A303 Sparkford to Ilchester Dualling Scheme TR010036

8.8 Draft Statement of Common Ground with Defence Infrastructure Organisation

STATEMENT OF COMMON GROUND

Version	Date	Status of Version
Rev A	January 2019	Draft for Deadline 2

Drawing Title  
**FIGURE 2.9  
LOCATIONS OF TEMPORARY WORKS AREAS REQUIRED  
DURING CONSTRUCTION - SHEET 2 OF 4**

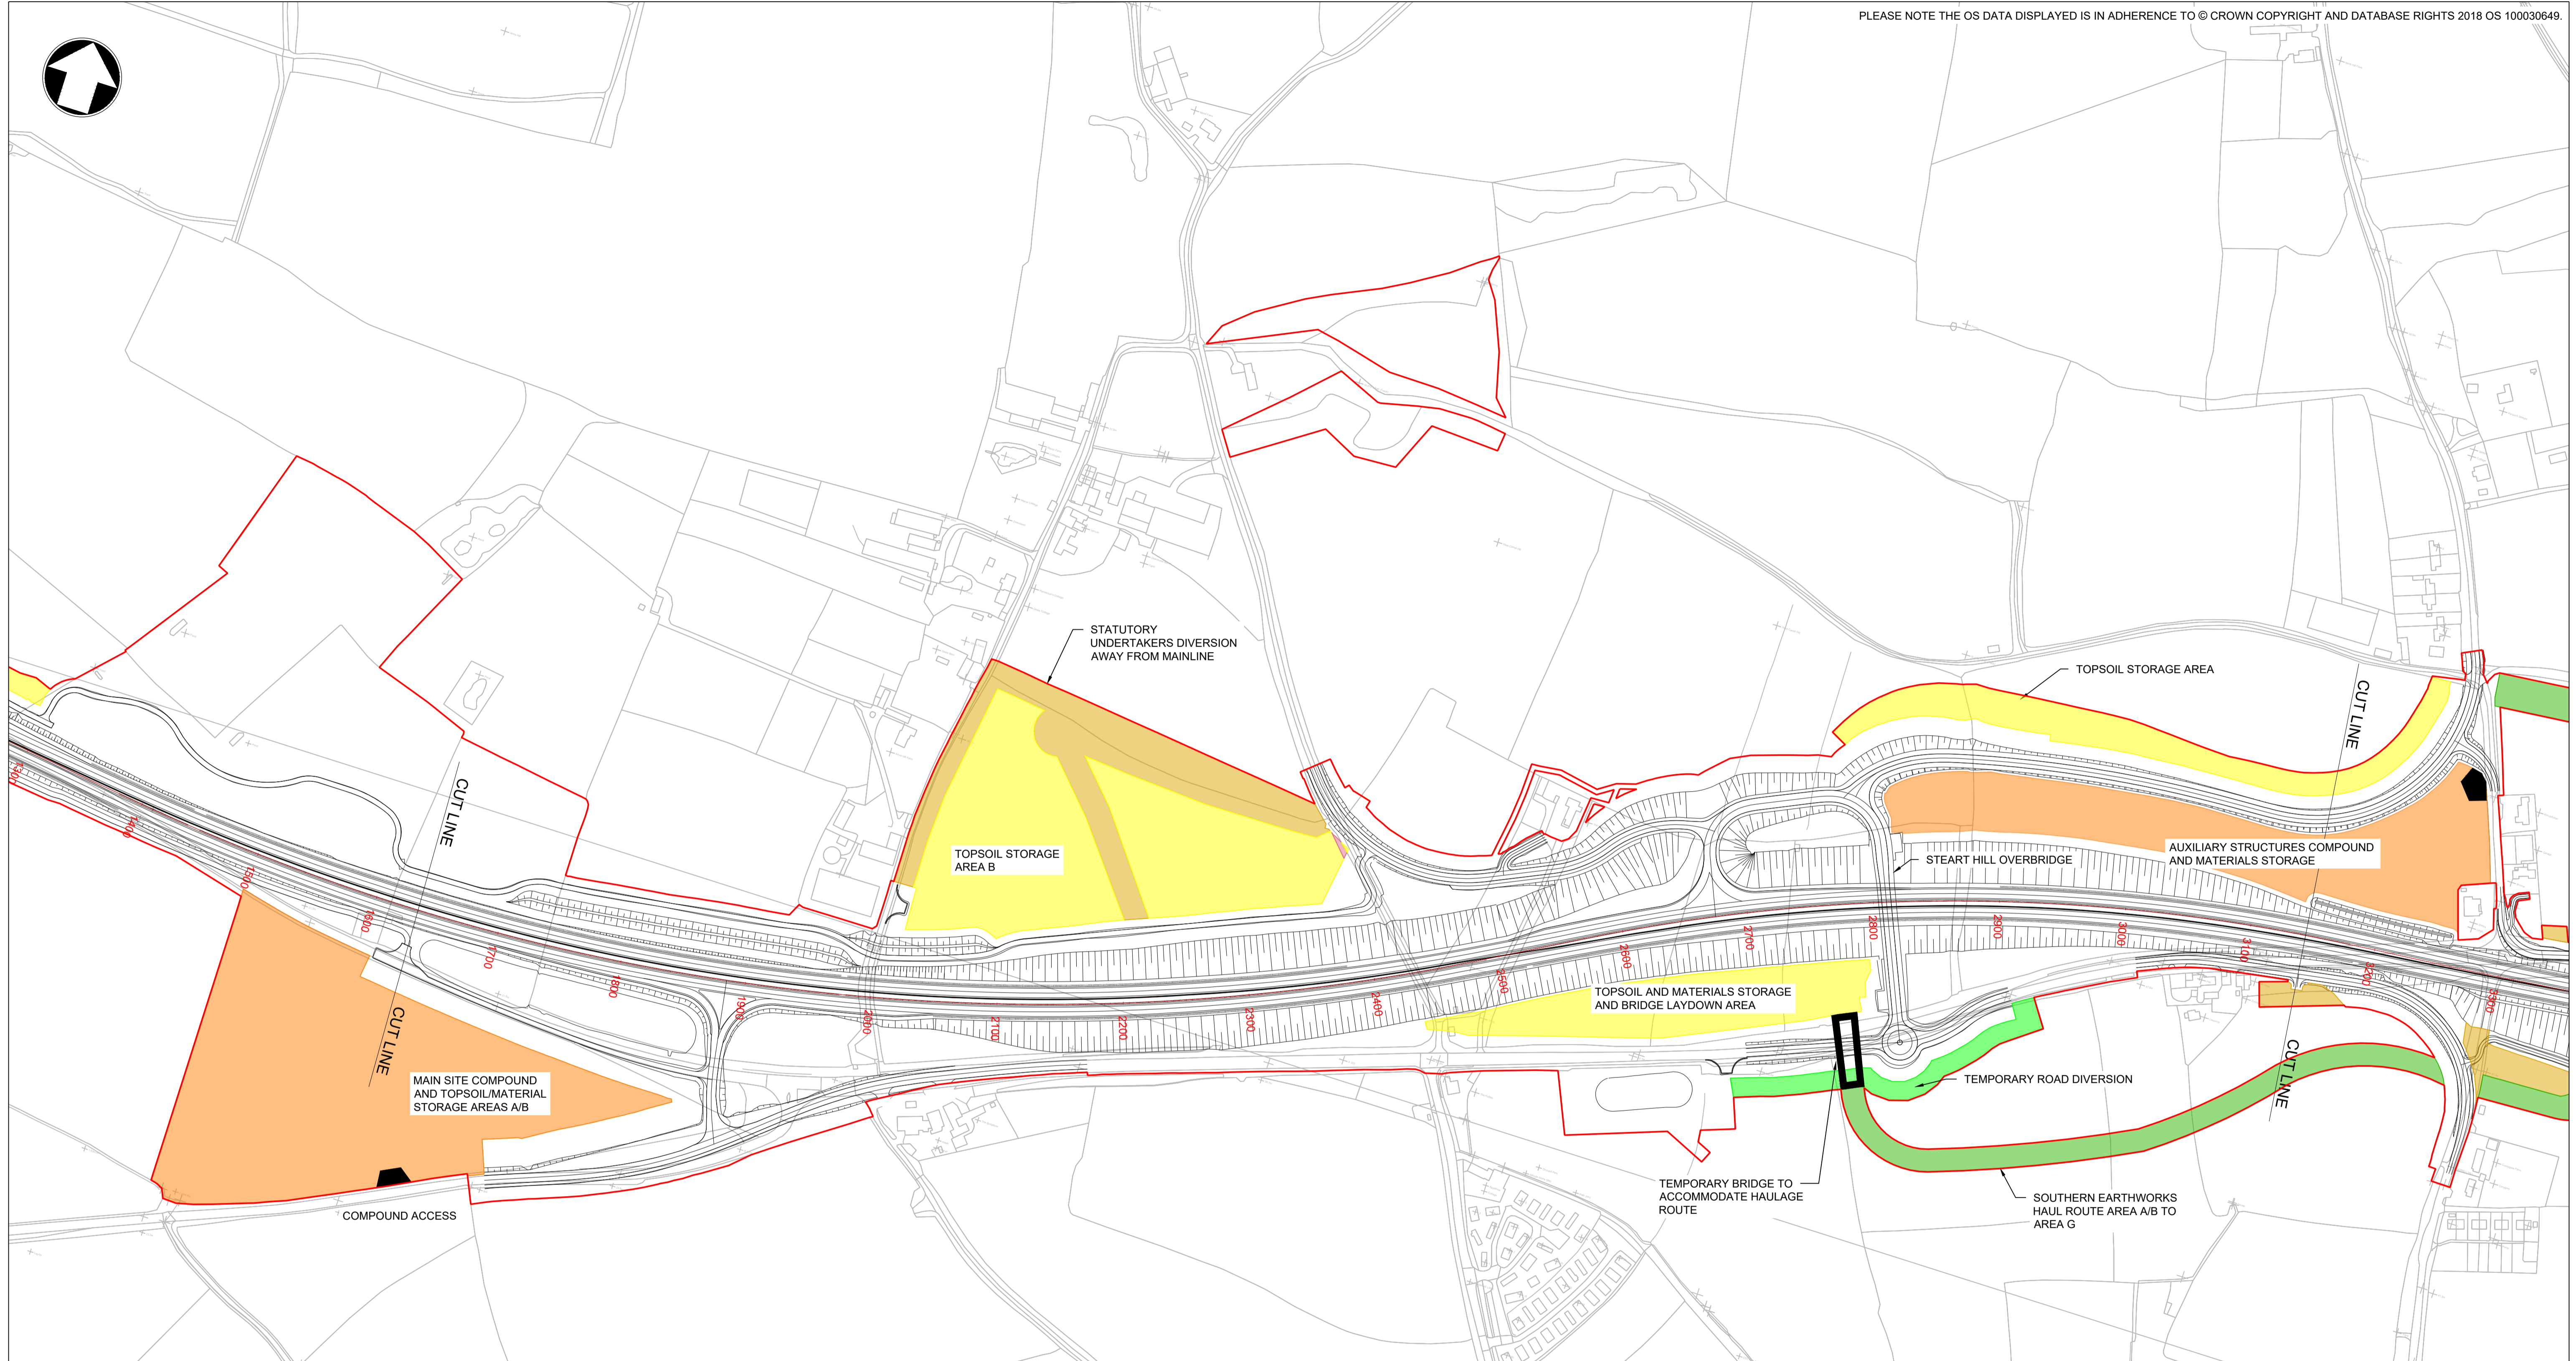
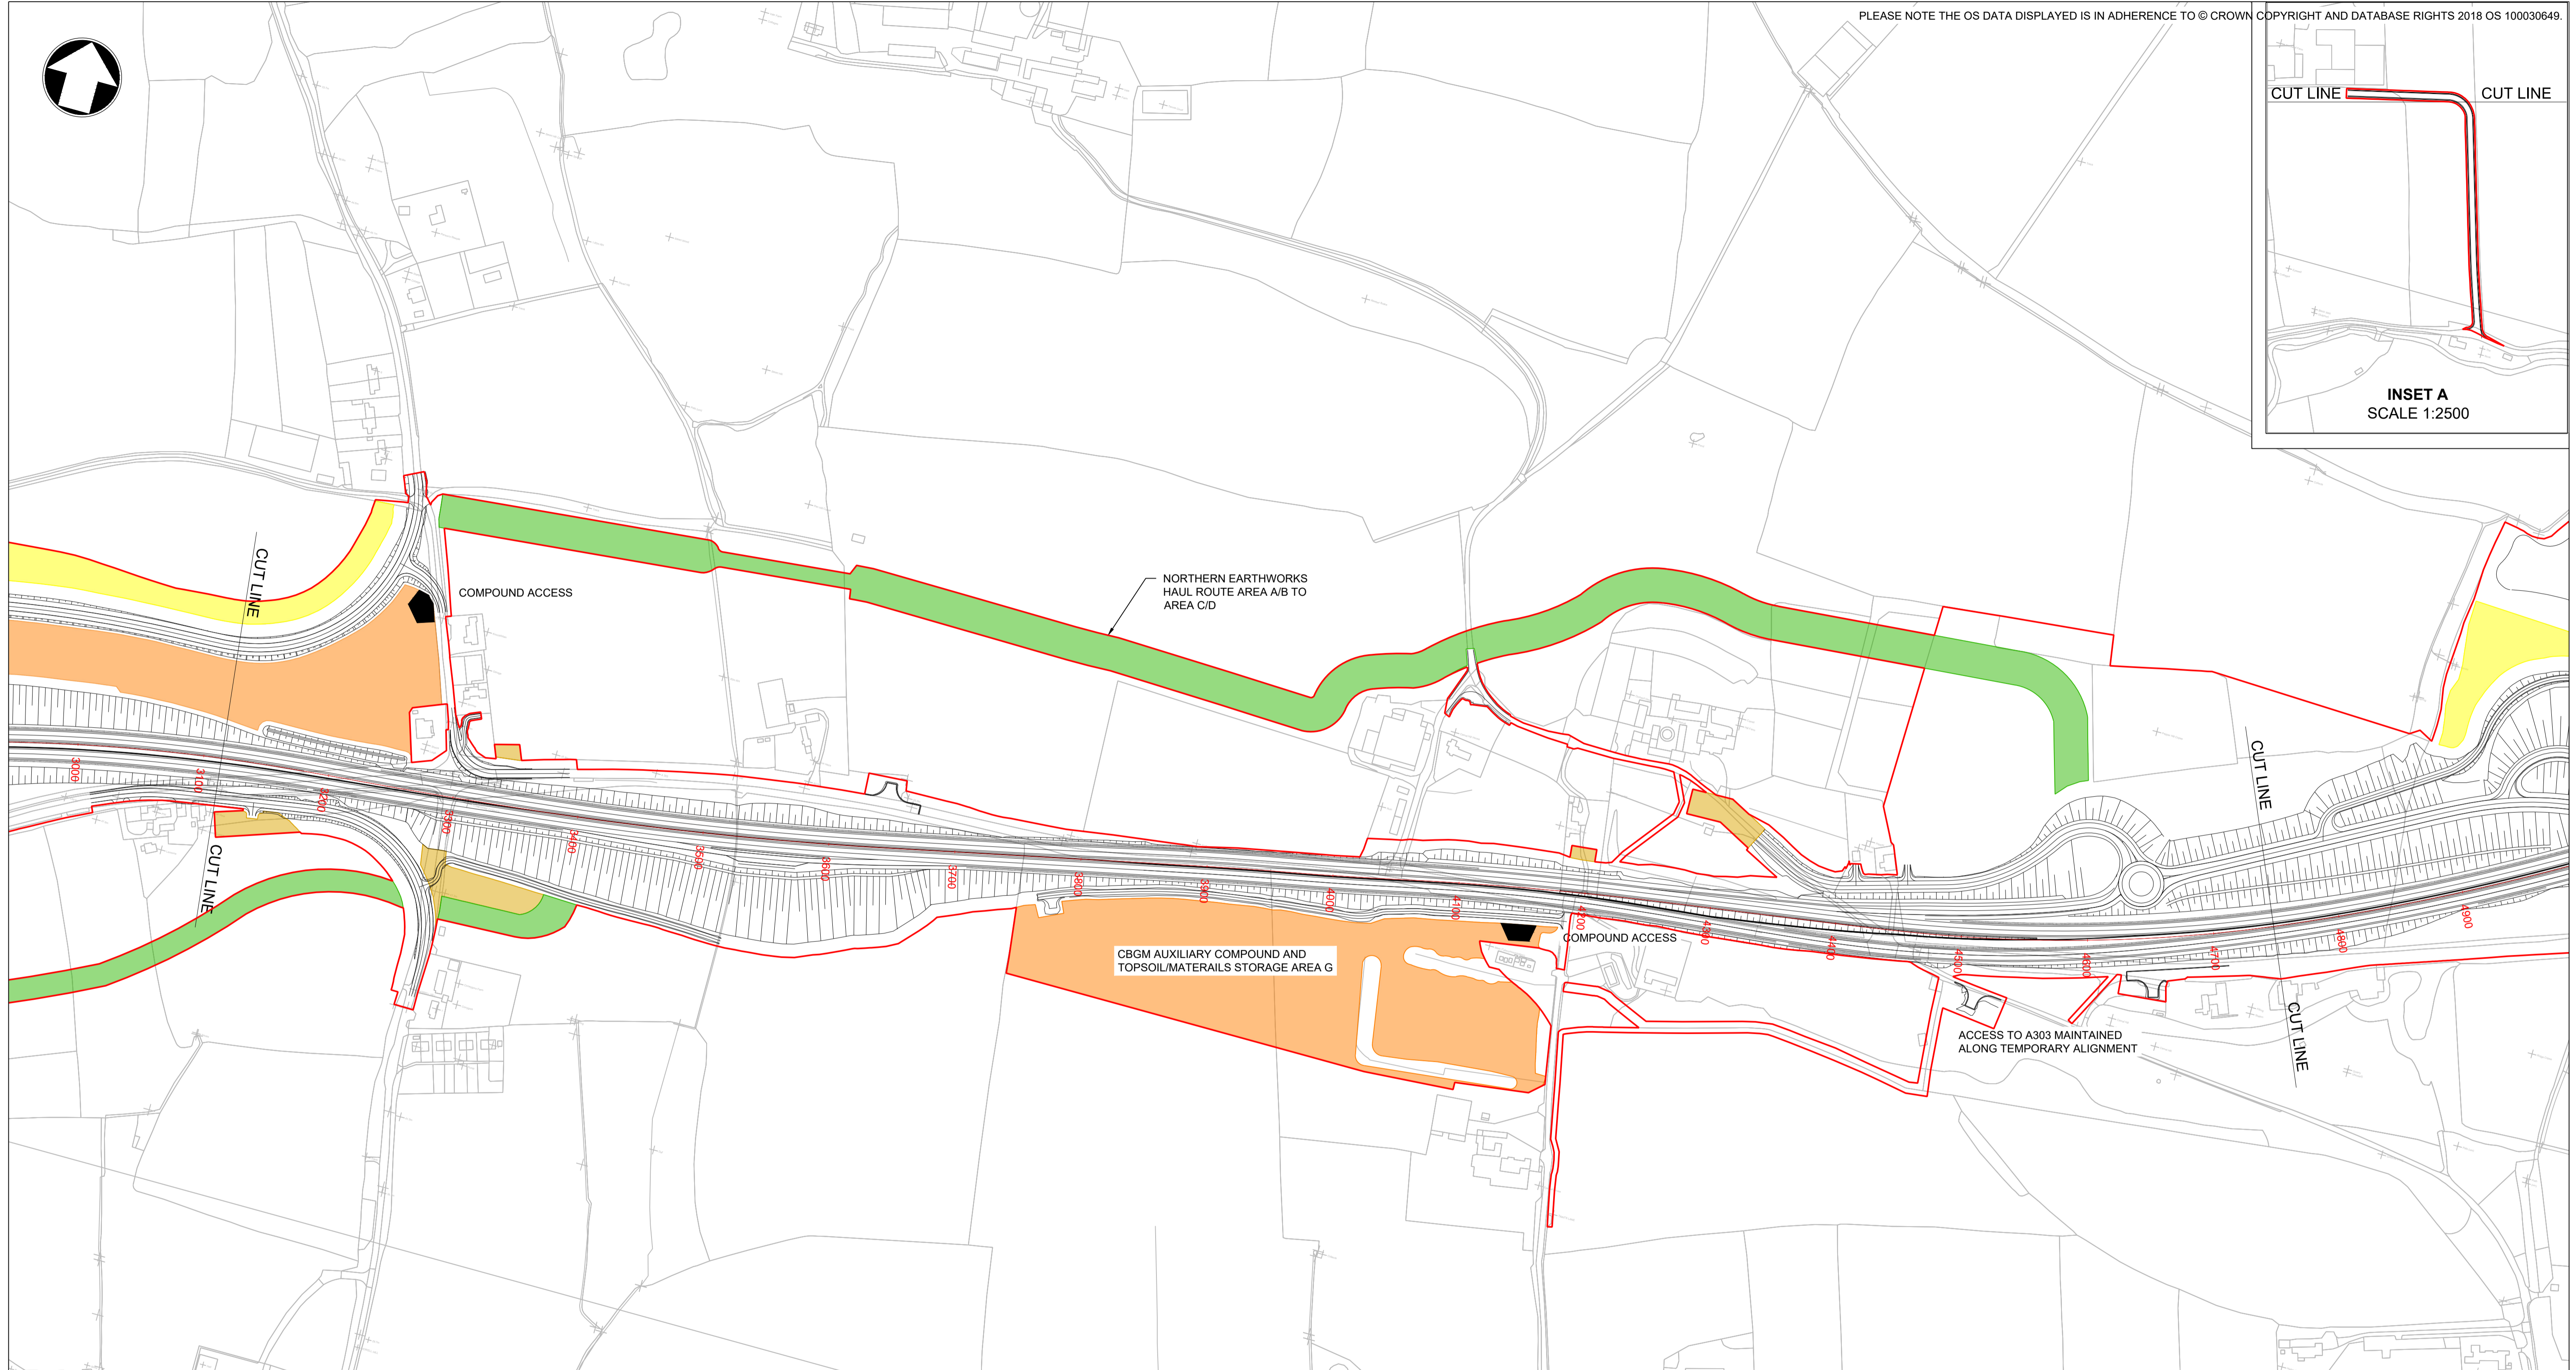
Access	Access to Camel Hill Signal Station	The DIO accept the proposed amendments to the access arrangements to this site	HE Acknowledged.	AGREED
Construction	Main site compound	The main site compound lies in the location for which new landing lights have been proposed. Potential for construction activities to interfere with these landing lights.	Highways England intend to submit a request to the Examining Authority to move the main site compound.	UNDER DISCUSSION
